Land fronting, Turnbull Road, Fradley, Lichfield

**Application by Massey Limited for the variation of Condition 2 of planning permission
REF: 18/O1693/FUL**

This Application is for variation of Condition 2 of planning permission 18/O169/FUL, 28th October 2020. That planning permission is for the erection of 8no. dwellings and associated works.

DRAWING TITLE
PLANNING | STREET ELEVATIONS

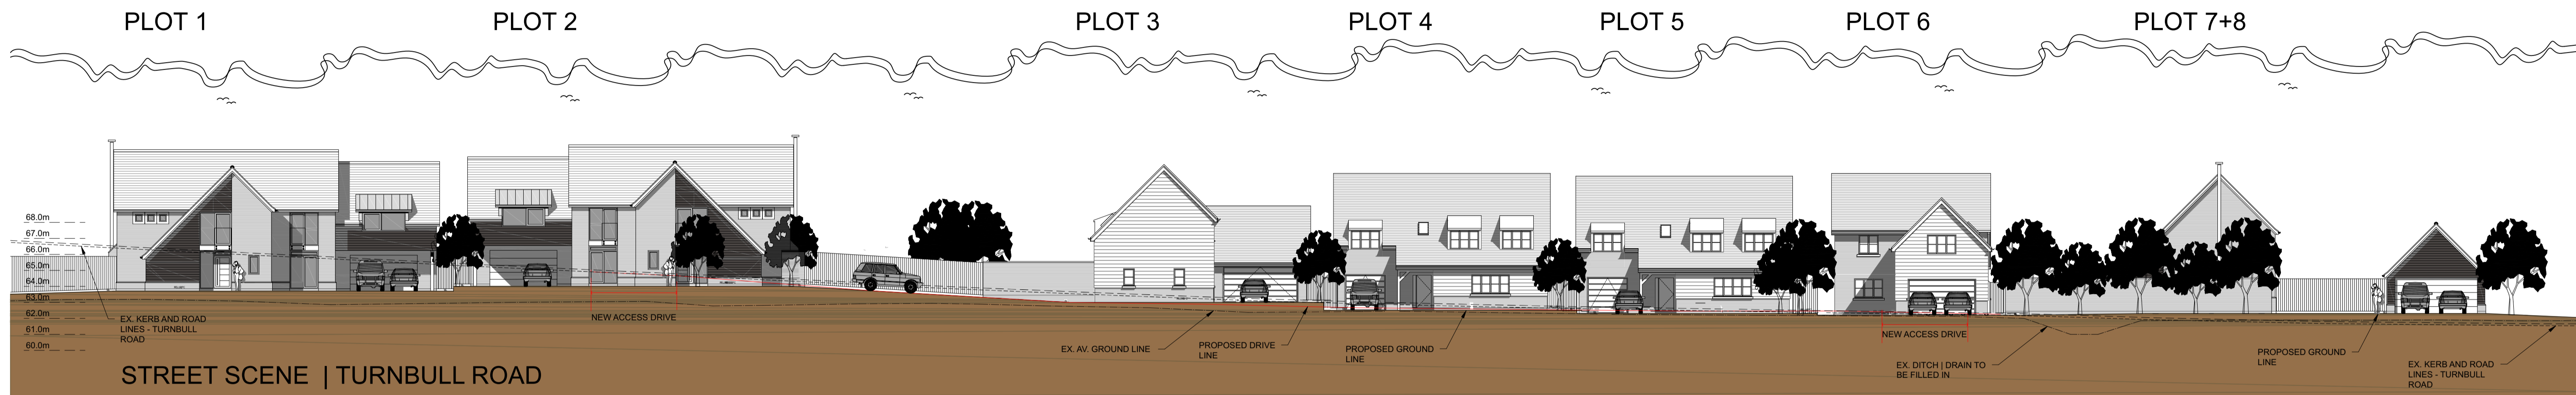
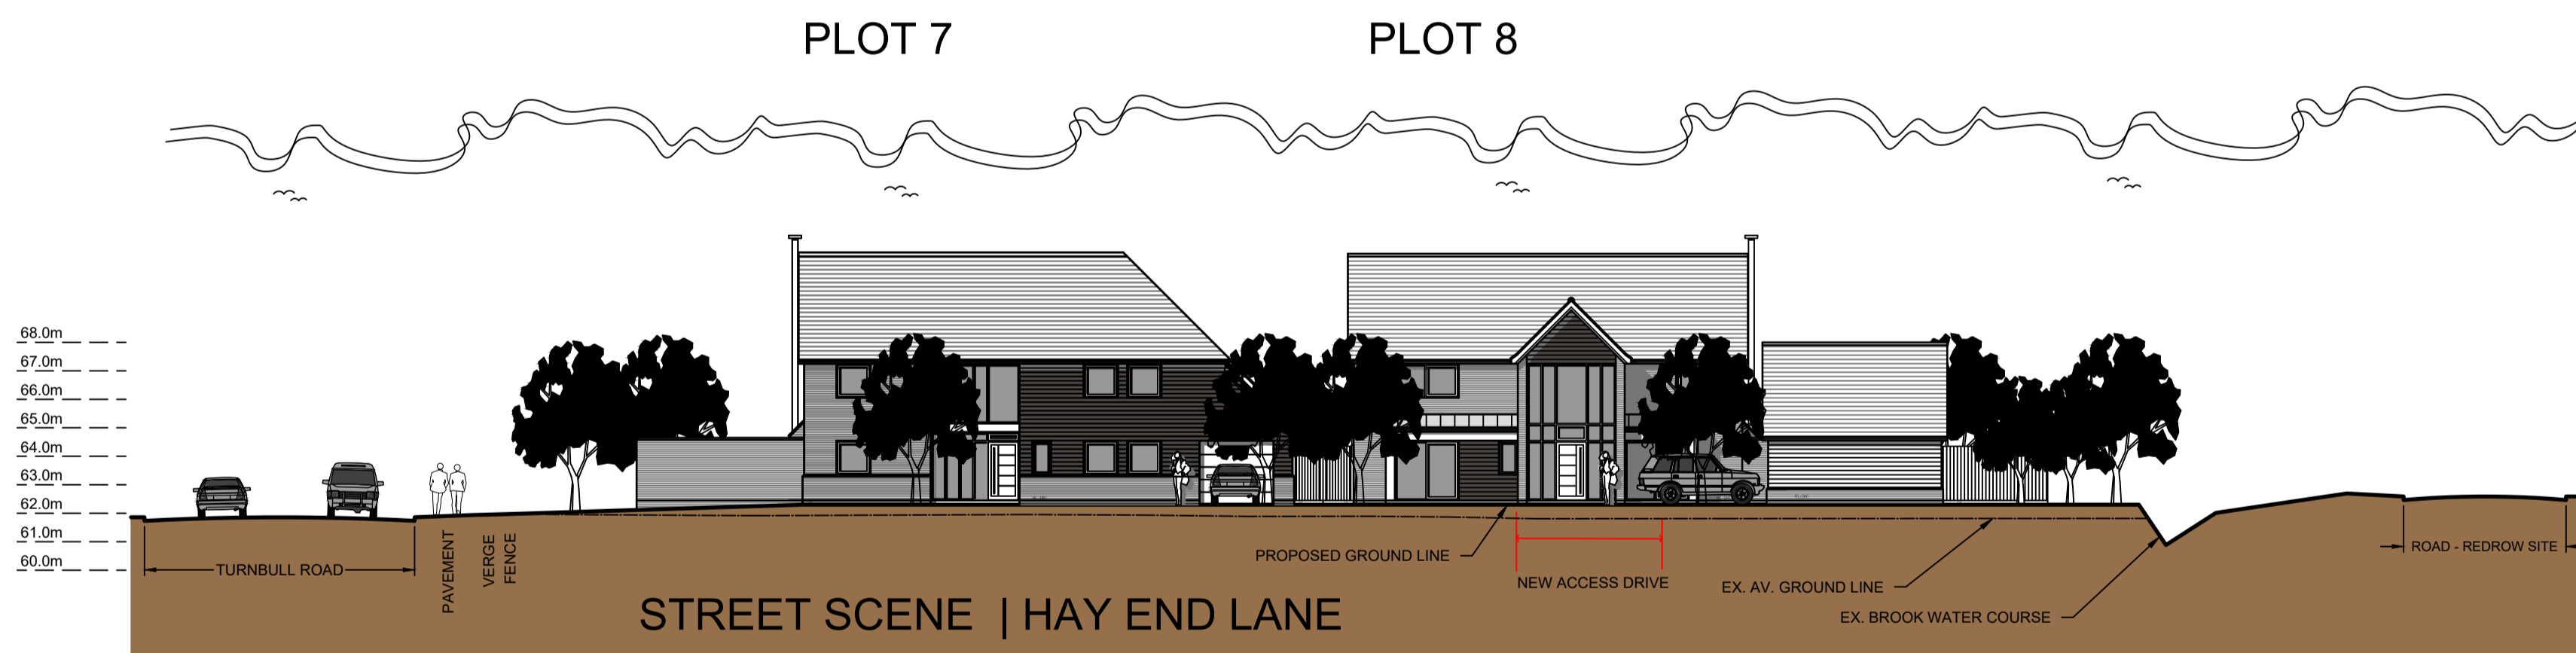
The consented site plan (18052_P_104D_O20319) allows for a 6m easement either side of the gas main that runs east / west across the northern end of the site. Cadent require an easement of 12m either side of the gas main. The proposed revised site plan (18052-P-104E_050121) allows for a 12m wide easement.

To accommodate the increased easement plots 3, 4, 5 & 6 have been reduced in width. Plots 1, 2, & 8 remain broadly the same as the consented design.
